**WEST SUSSEX COUNTY COUNCIL
STRATEGIC PLANNING CONSULTATION**

DATE: 12/05/2014

SUBJECT: WA/21/14/PL - Demolition of garage and workshops and erection of 6 No 3 bed dwellings, alterations to access, parking and incidental sheds for cycle storage. This application affects the character and appearance of the Walberton Village Conservation Area.

Turnpike Motors, The Street, Walberton, West Sussex, BN18 0PG

**Proposed site plan and
Street Elevation**

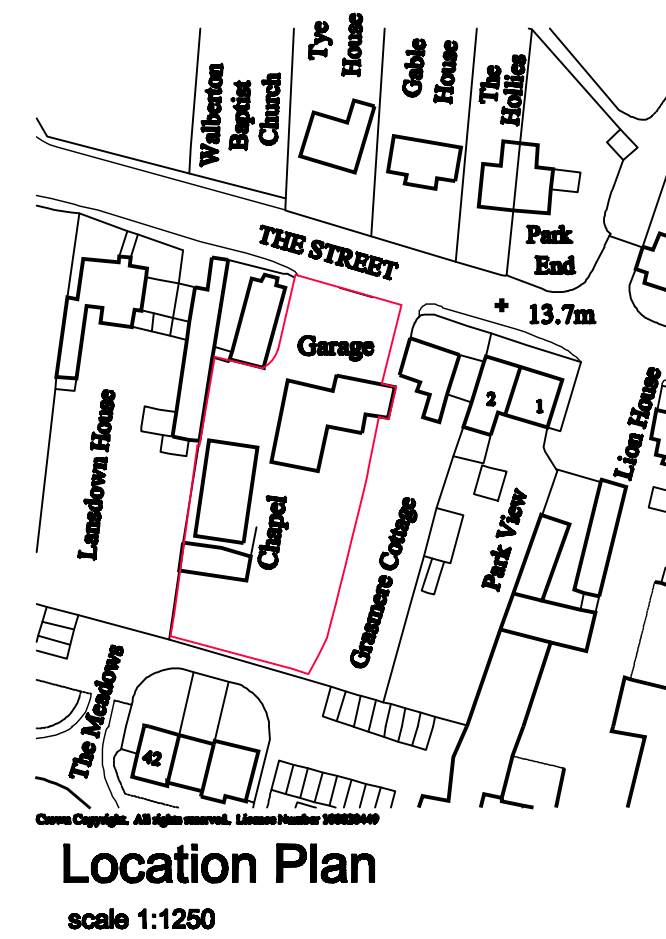
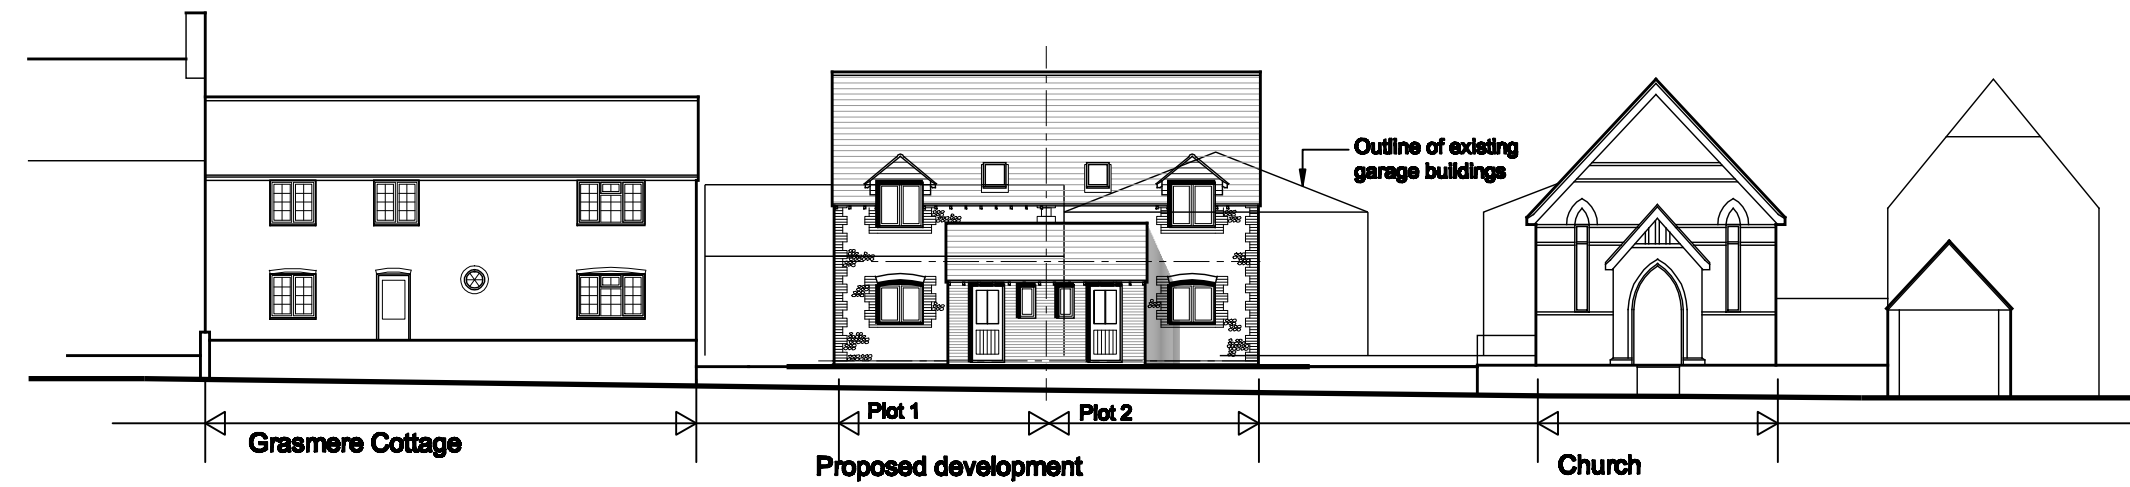
A total of 12 car parking spaces will be provided on site. This provision has been considered against the WSCC Parking Demand Calculator. The proposed provision does exceed the requirement generated by way of the PDC. In terms of parking layout there is sufficient space within the site for vehicles to turn and enter the highway in the forward gear.

No part of the development shall be first occupied until the car parking has been constructed in accordance with the approved site plan. These spaces shall thereafter be retained at all times for their designated purpose.
